**Re: Landowner's Consent Application – LOC Reference Number: 10669
Address: Northern Promenade at The Rocks, Darling Harbour**

- **Revised Concept Plan for the Northern Promenade at The Ribbon that Grocon**

STRUCTURE/FURNITURE AROUND PYLONS

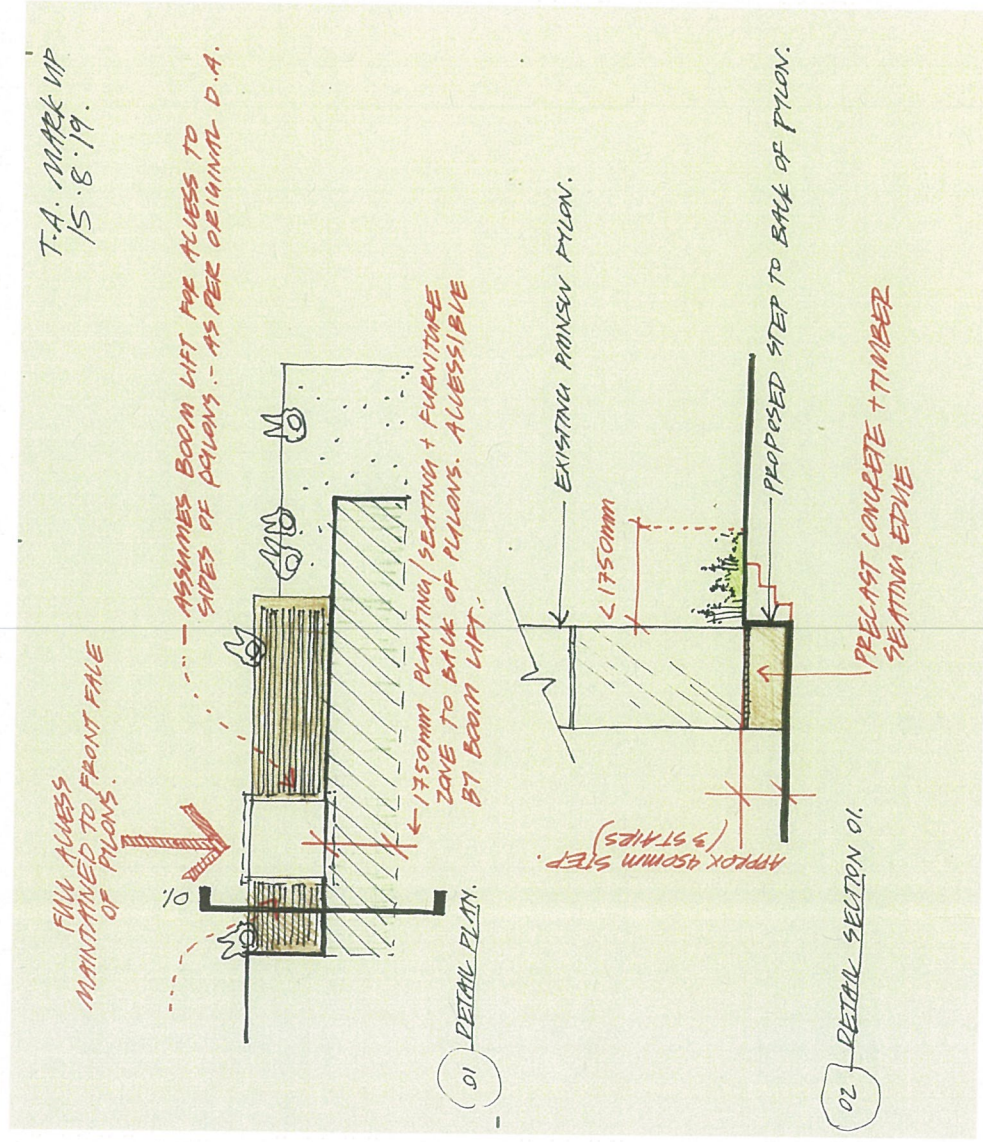
- The extent of the green planter at the eastern end of the ramp is to be further rationalised in size to ensure a more open transition /level change is achieved in accordance with details to be submitted to PMNSW prior submission of the S4.55 modification for assessment.
- The proposed public seating around the Western Distributor pylons shall be designed to provide access to RMS work crews for maintenance as required.
- Grocon to work with PMNSW during the DD period to enhance the features eg: public seating and ensure this revision is integrated with surrounding areas eg: approach gradients from ICC.
